DEVELOPMENT REVIEW BOARD
TRANSPORTATION DEVELOPMENT

DRB Project Number: 1011517
Eastern Addition

SUBJECT: Preliminary/ Final Plat, Design Variance

Project #:1011517

"EXHIBIT"
OF
LOTS 3, 4, 5 AND 6, BLOCK "L"
EASTERN ADDITION

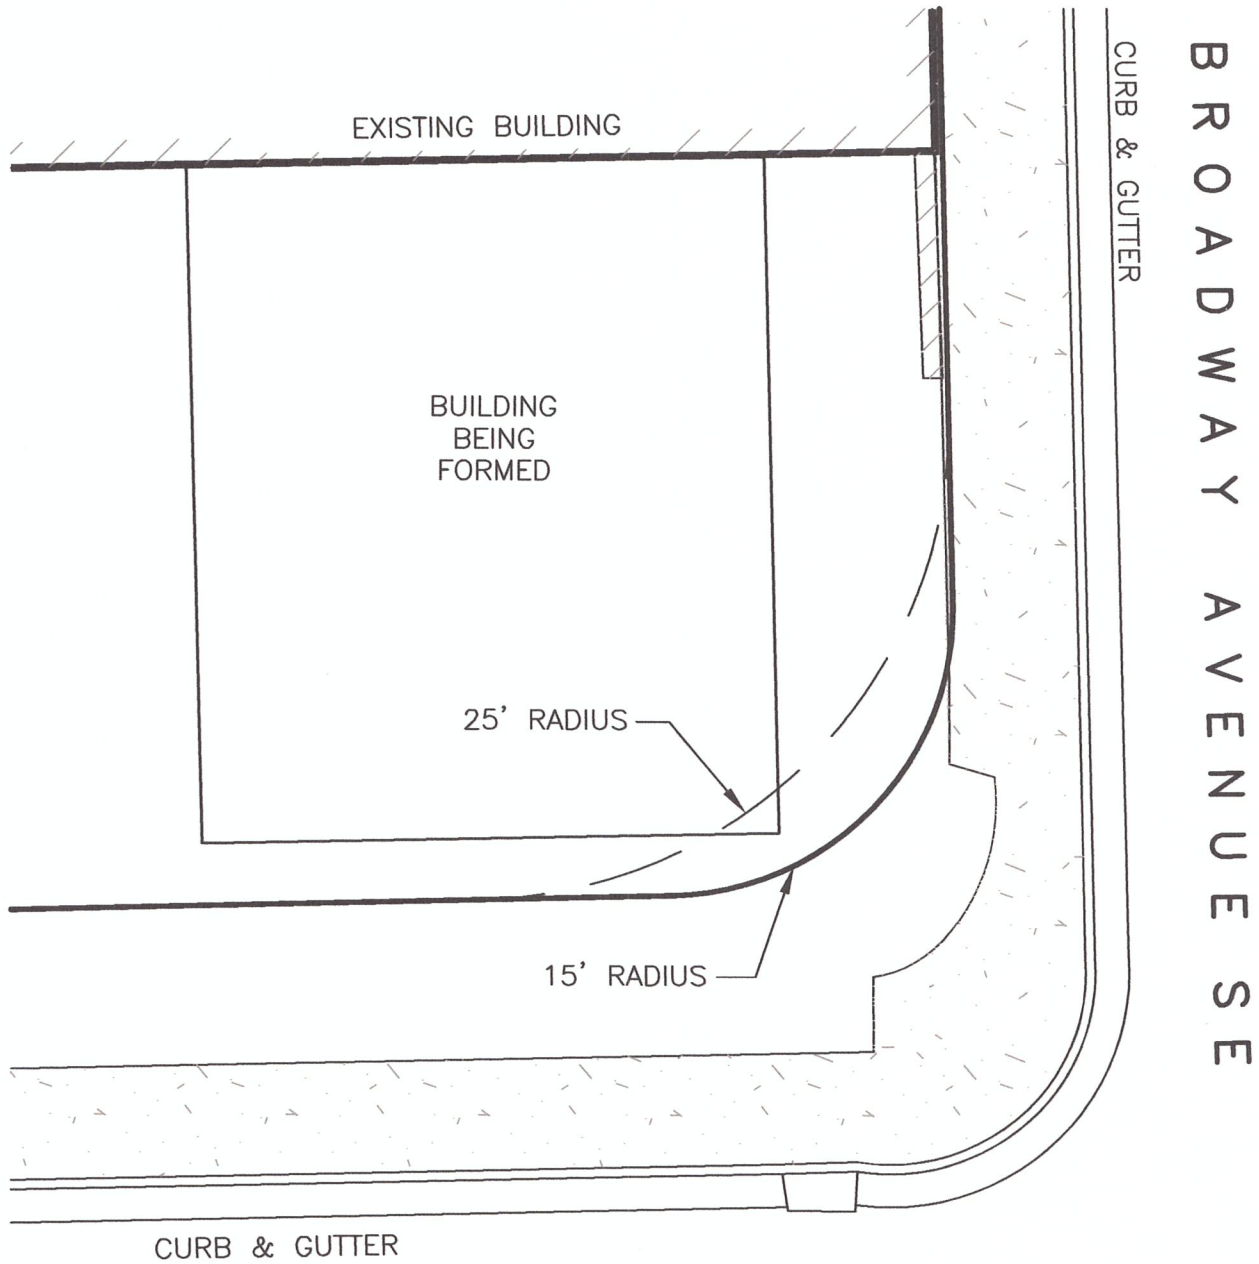
1. Is this a development of a new building? There are steps that may be in the new right of way.

- Exhibit for variance to design standards states that the “building being formed” but I am not sure what that means. Does the exhibit only show the existing conditions on all the lots or just one??
- No adverse comment to the platting action
